MECKLENBURG COUNTY
Park and Recreation Department

MEMORANDUM

RE: Rezoning Petition #2022-160
PID# 05302210, 11, 12, 19, 20, 21, 25

RZ1.00

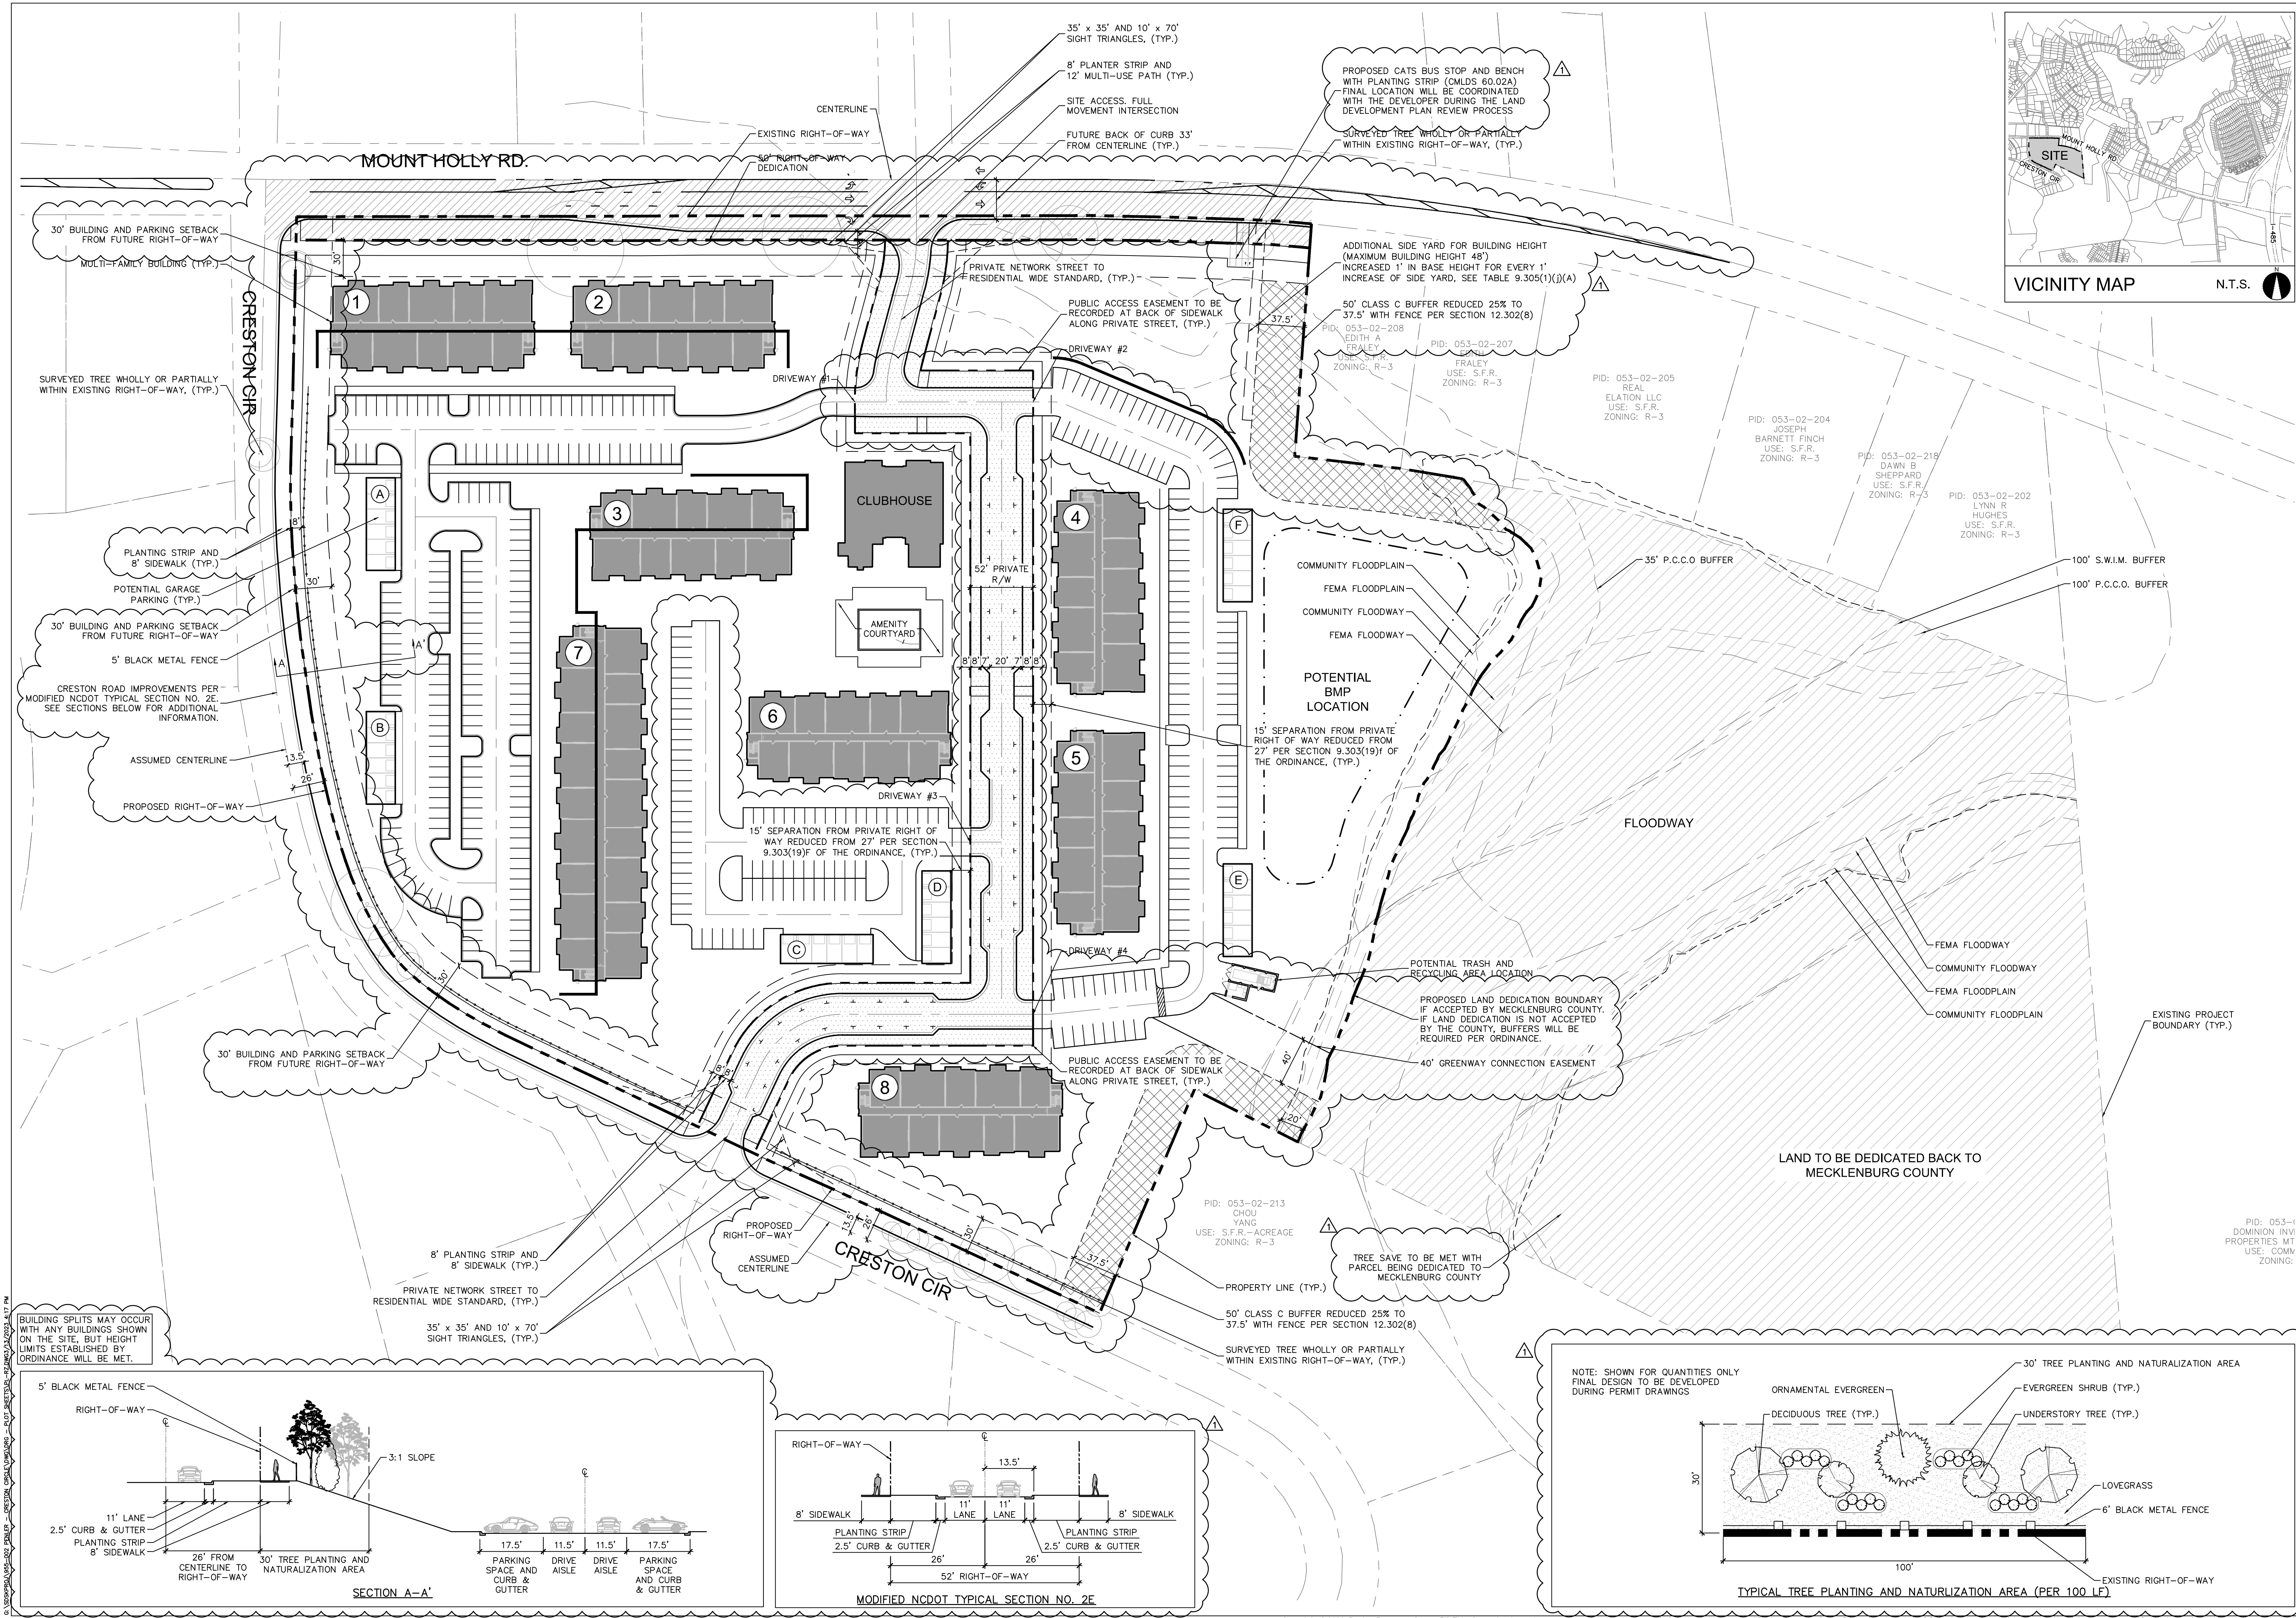
Please extend the proposed access easement to the development public street ROW as shown in Plan Room so that Mecklenburg County may access the dedicated parcel area.
